From: Amanda Scholes on behalf of Planning.Responses
Sent: 20 November 2018 08:10
To: Planning Scanning
Subject: FW: Land at Lidsey AL/20/18/OUT
Attachments: SP_OCL_SR_502_B.pdf

From: Clare Bartlett [REDACTED]
Sent: 19 November 2018 16:17
To: Michael Eastham
Subject: FW: Land at Lidsey
Importance: High

From: Steve Reeves <[REDACTED]>
Sent: 19 November 2018 15:53
To: Clare Bartlett <[REDACTED]> Chris Harris <[REDACTED]>
Cc: Lynn Gilbert <[REDACTED]>
Subject: RE: Land at Lidsey
Importance: High

CHA have raised a new issue about the risk that HGVs 'might over-sail the centreline when travelling south'. The drawing OCL/SR/701 Rev D shows that the route of the A29 is widened to at least 3.75m per lane, widening to 4.25 per lane at the access. Circa 10m to the south of the new access the lane widths are 4.15m each. The correct plans and the swept paths showing that two HGVs could pass each other with ease were attached to the original Transport Statement. For reference, I have attached the swept path to this email. As you can see there is plenty of room between the two HGVs as they pass each other. The camber of the A29 will also mean that HGVs will be leaning away from each other. Th

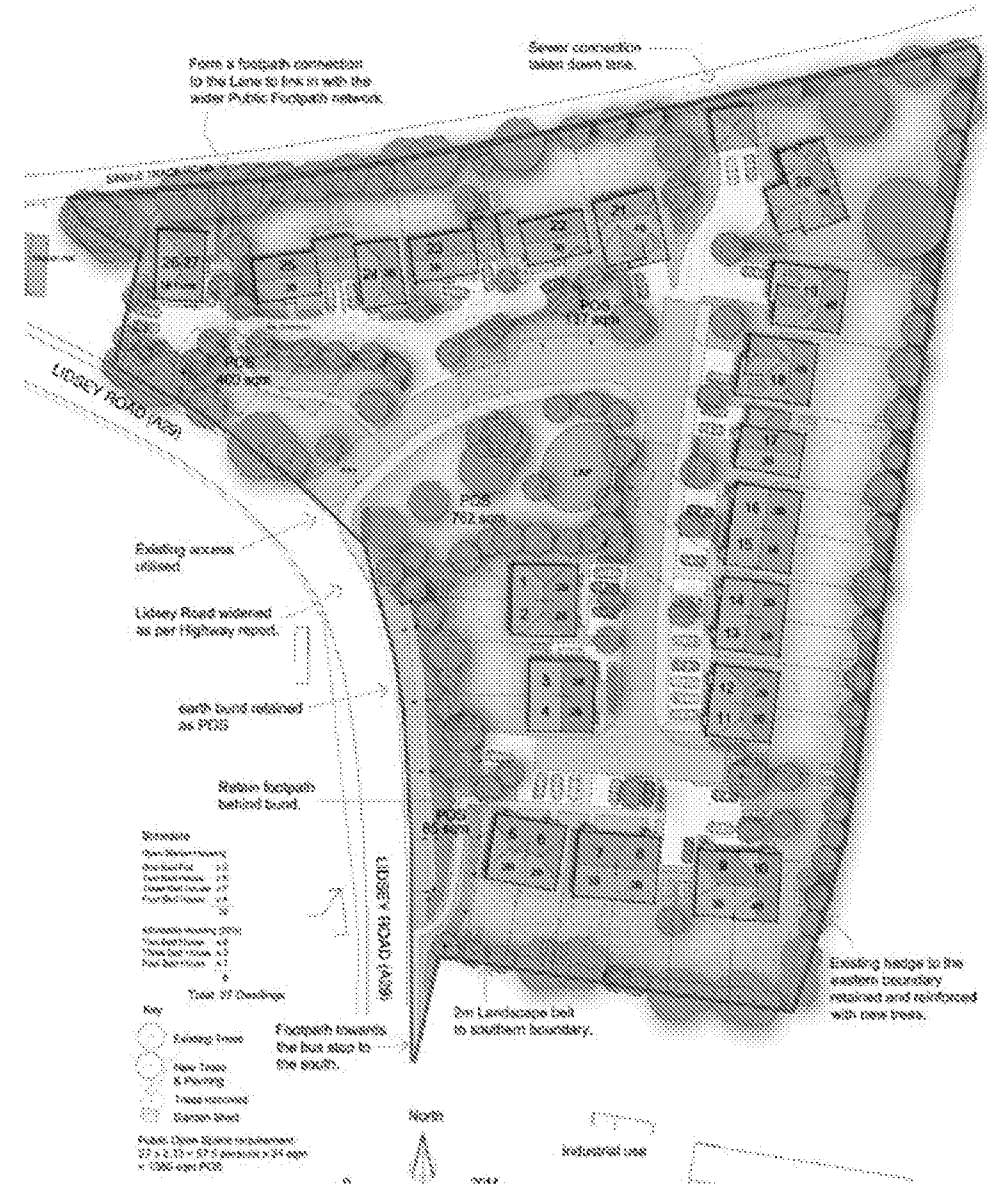
CHA are referring to DWG 1749-02H in the comments about the bellmouth. This is the 'Illustrative Site Plan' of the proposal. We have shown on OCL/SR/701 Rev D the appropriate detail of the bellmouth and the reasoning for the tightness of the radii has been discussed in great detail. CHA had agreed that the detailing of the bellmouth can be agreed at the detailed design stage, once the scheme has been subjected to the Stage 2 Road Safety Audit.

It would seem that the CHA are now basing their concerns on the 'Illustrative Site Plan' DWG 1749-02H. It is not unusual for there to be some discrepancies between illustrative plans submitted as part of the application and (in this case) the 4th iteration of the highway layout plan. We have provided more than enough information to show that the access can be designed to accord with the required design standards and that the use of the access will not create an impact that can be defined as severe.
